Re: Integrated Acute Services Building (IASB Addition) – Preliminary BCA Compliance

This letter has been prepared to provide preliminary advice for the proposed IASB Addition. The proposed works have been assessed against the current provisions of the BCA2016 Amendment 1.

This report is an addendum to McKenzie Group BCA Report previously submitted under SSD 9113 Prince of Wales Extension Stage 1. The content of this report relates only to the additional core scope elements of the IASB Addition.

HOSPITAL - GENERAL
ARRANGEMENT PLAN -
LEVEL L09

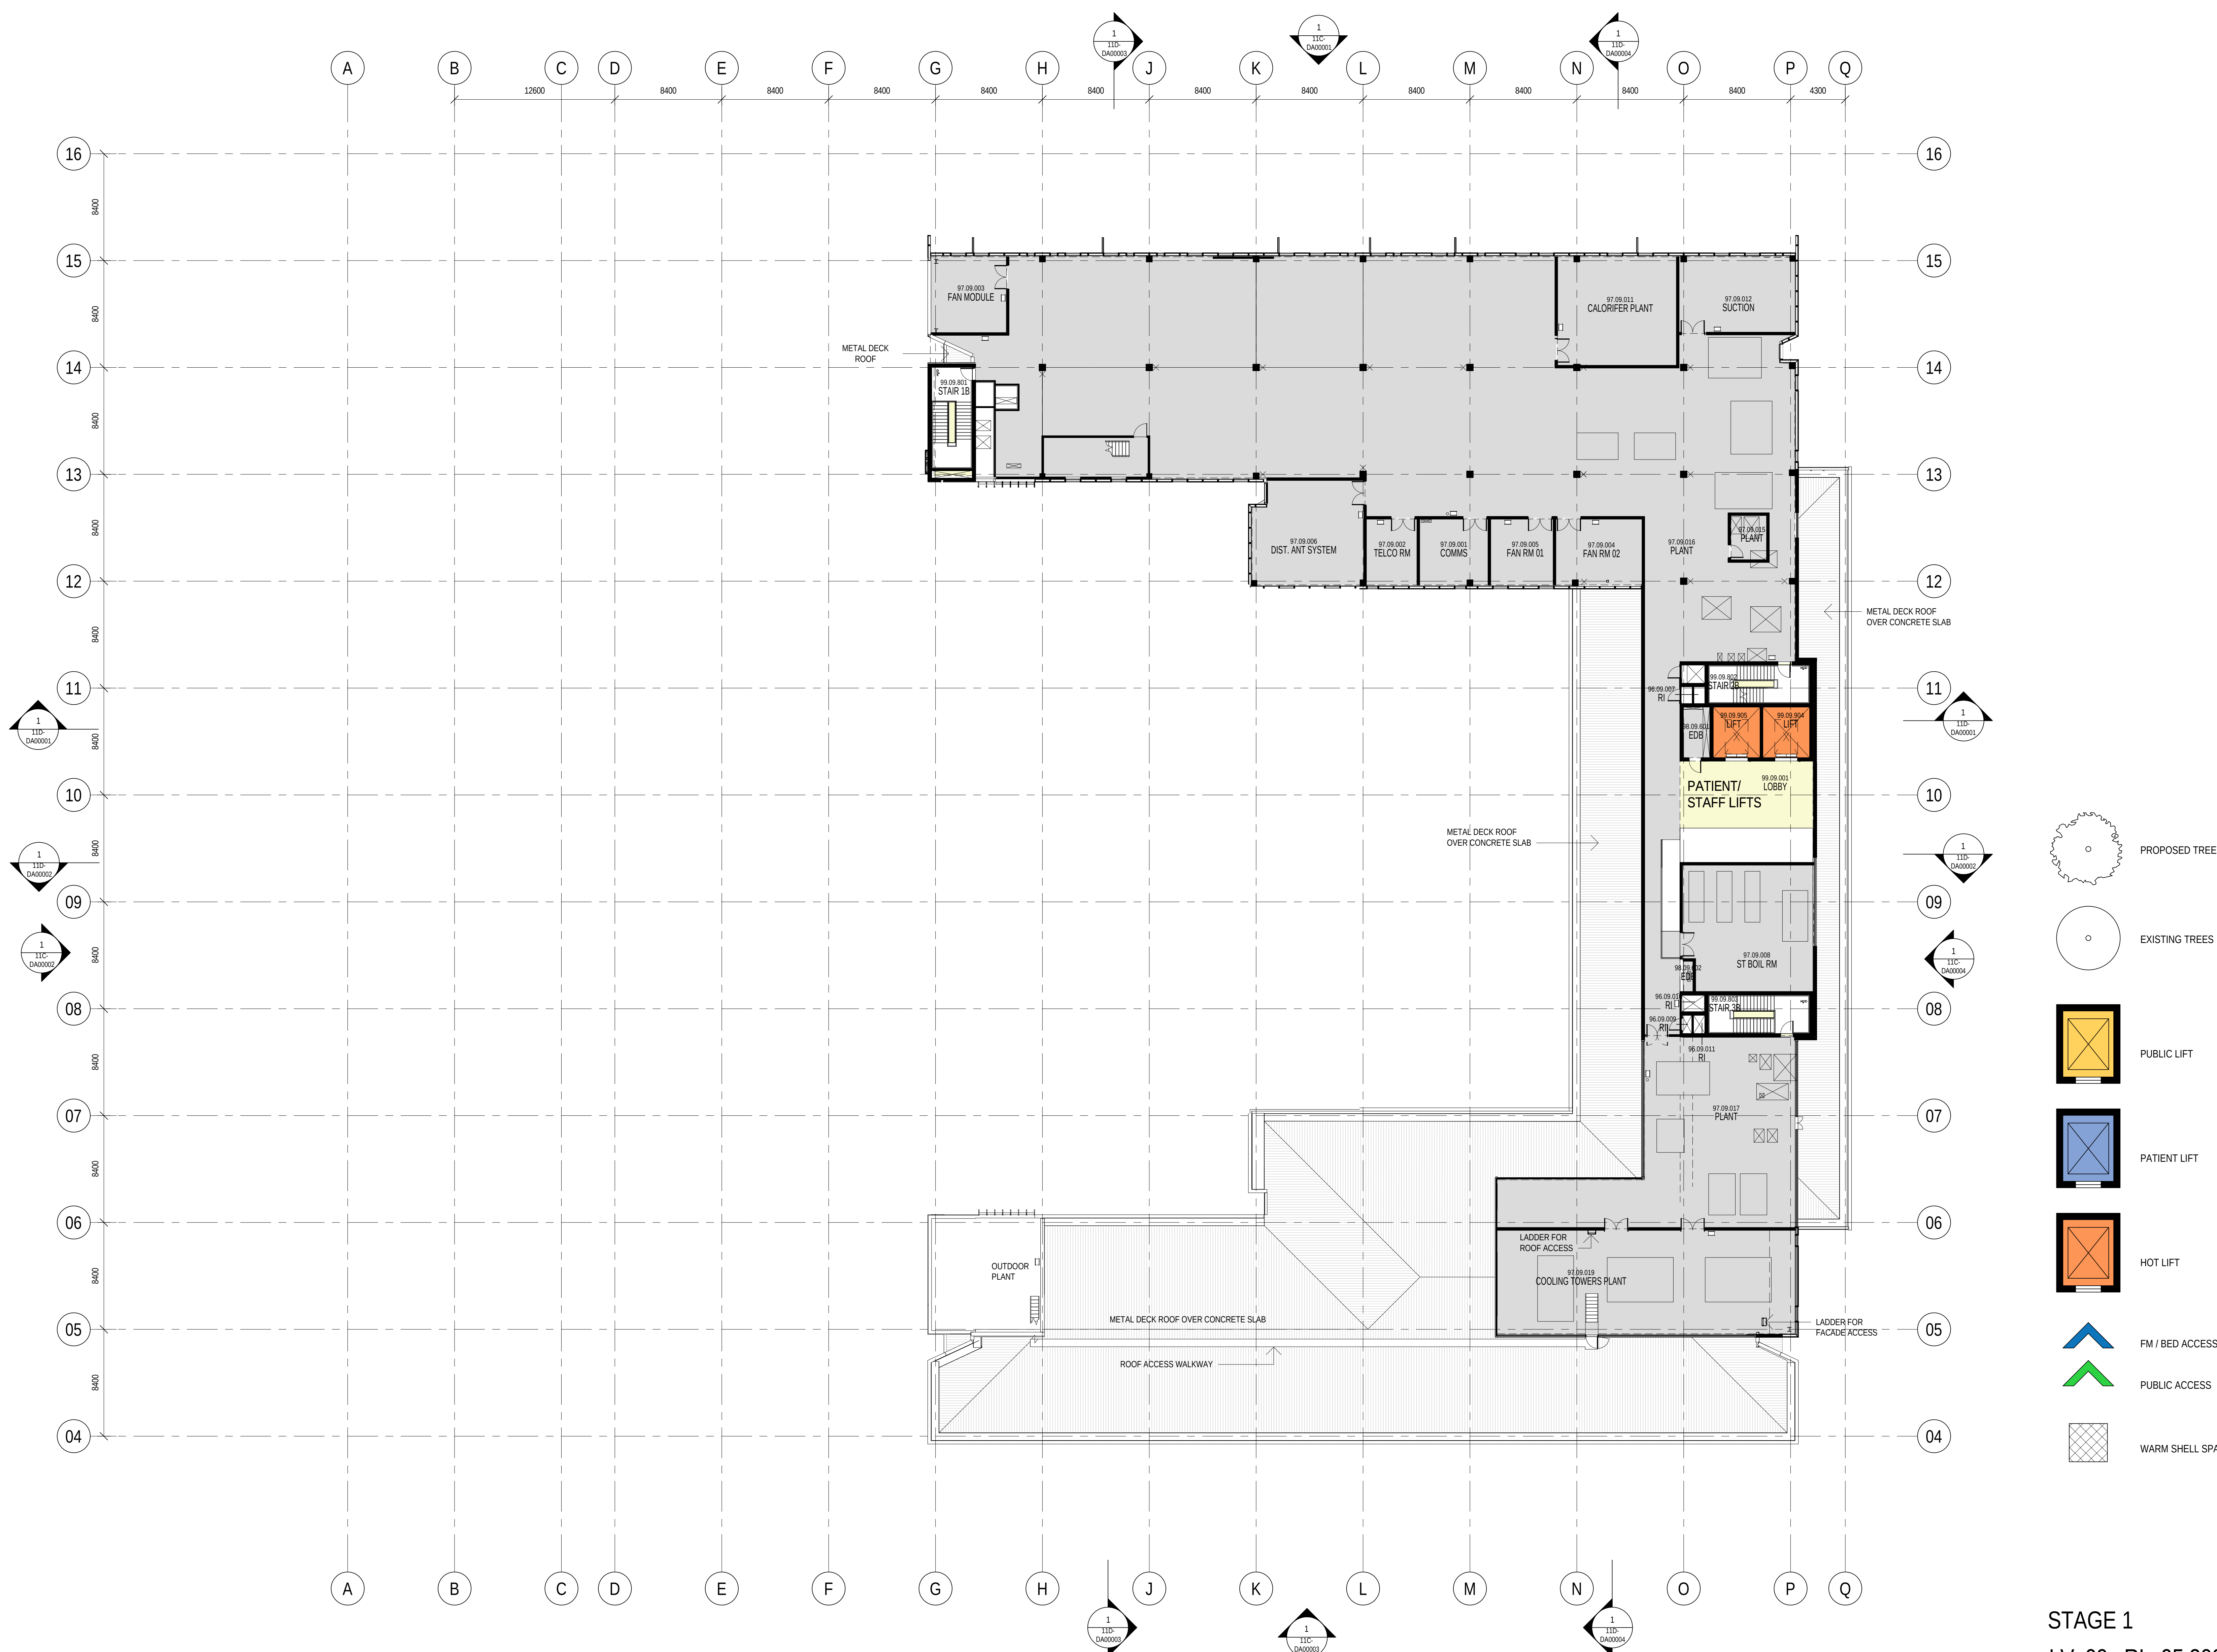
7.	Door thresholds (D2.15)	A step at the threshold of the doorway leading into the plant room (level 09) is not permitted. Design amendment will be required prior to CC.
